Response to Comments: 65 Munjoy Street Condominium Development

Date: January 27, 2016

Comments Submitted by: Nell Donaldson, Planning Division on 2015-12-31

L-101

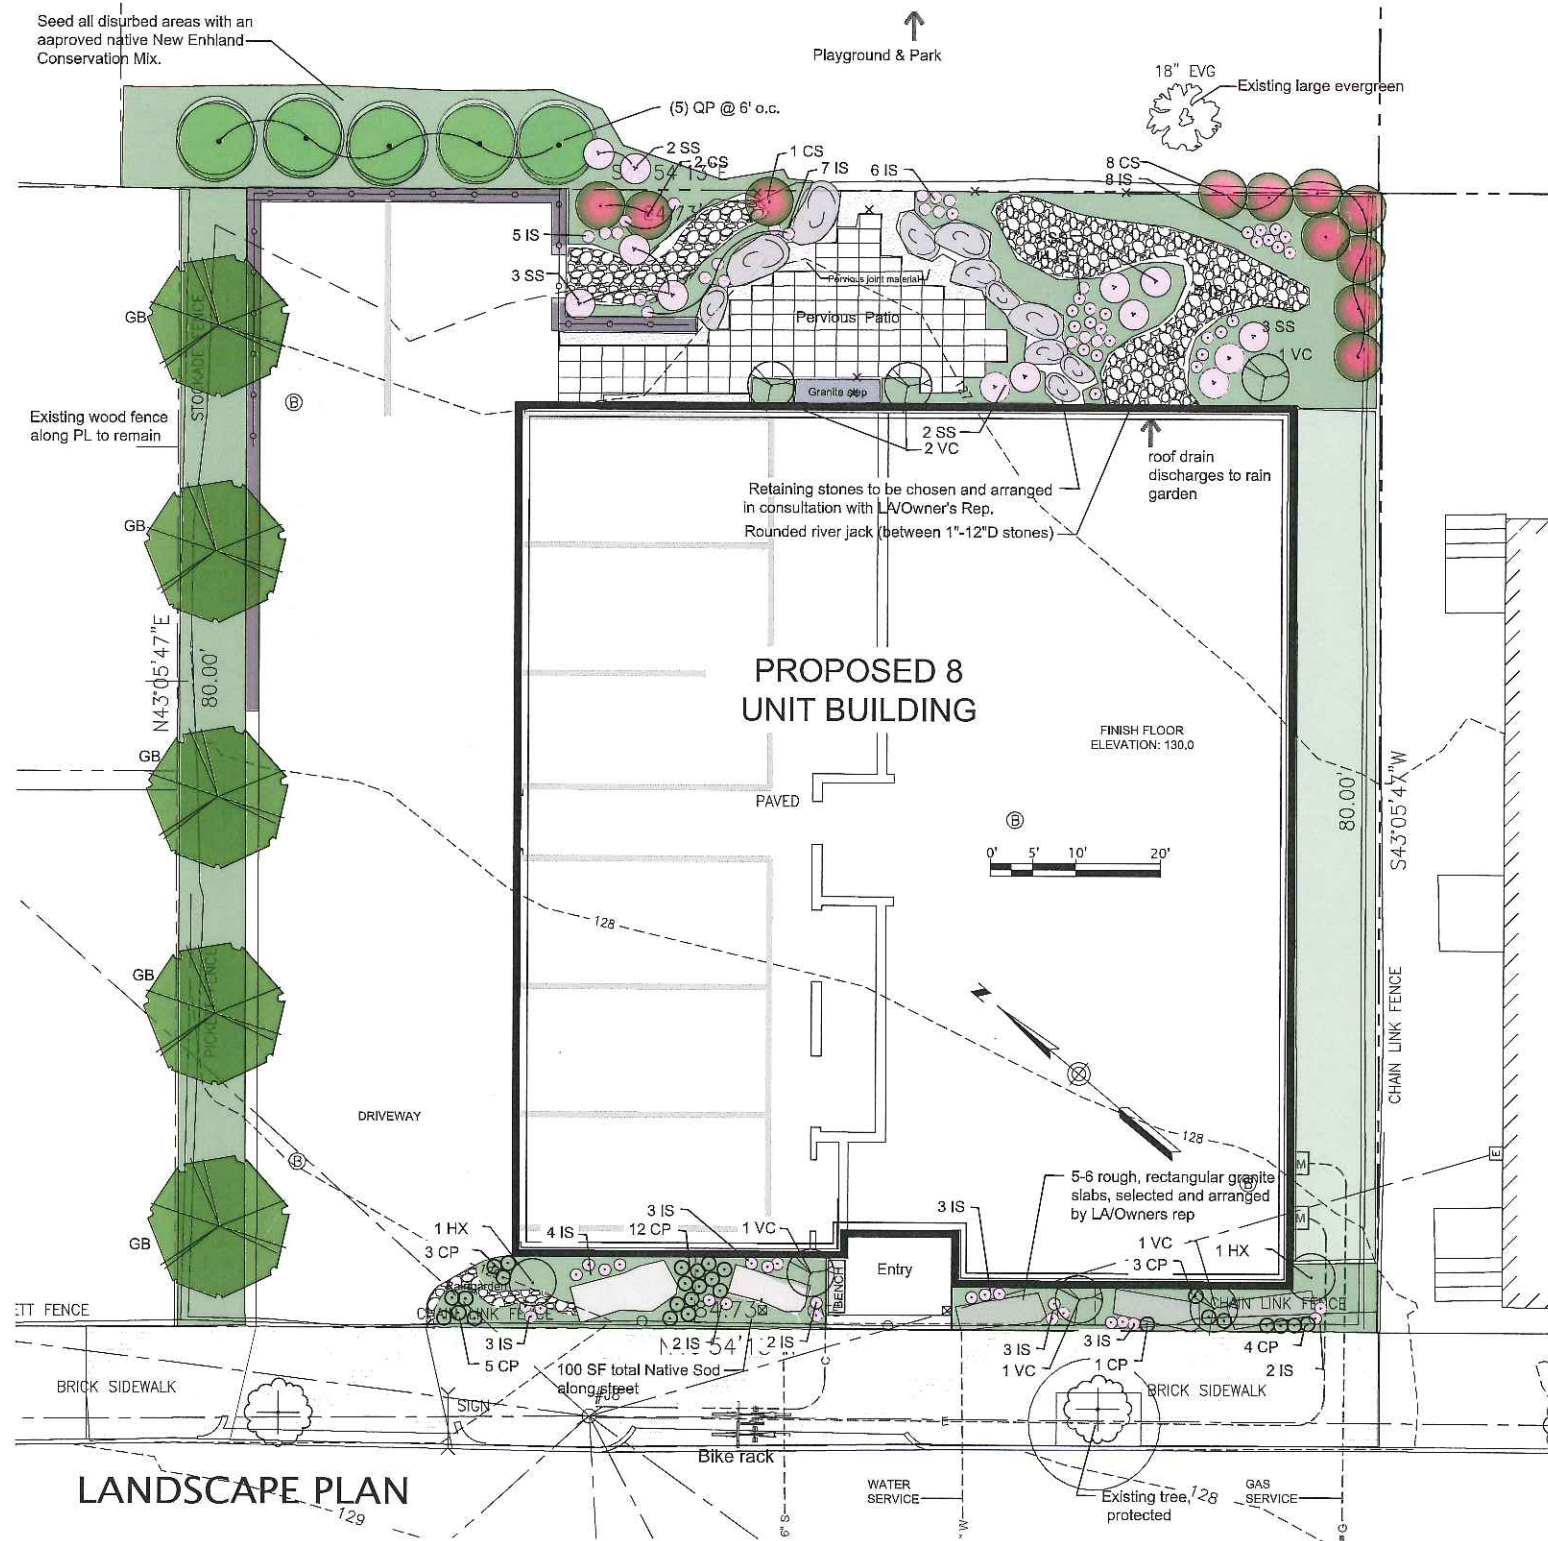
1. Overall the landscape plan works for this site. To meet City landscape standards the proposed 'Green Pillar' Oak should be 2" caliper vs 1.5". They could use "Regal Prince' variety of upright Oak also for the same effect with perhaps a better cultivar.

2. The sidewalk tree cut out should be rectangular in shape with a minimum width of 3.5' depending on ADA sidewalk requirements between back of sidewalk and the tree. Ideally we would like to see 4' width tree pit; the length should be roughly 7'.

Response: The landscape plan has been adjusted to indicate 2" caliper trees and the suggested cultivar.

Response: The tree pit has been adjusted to be 7' long by 4' wide.
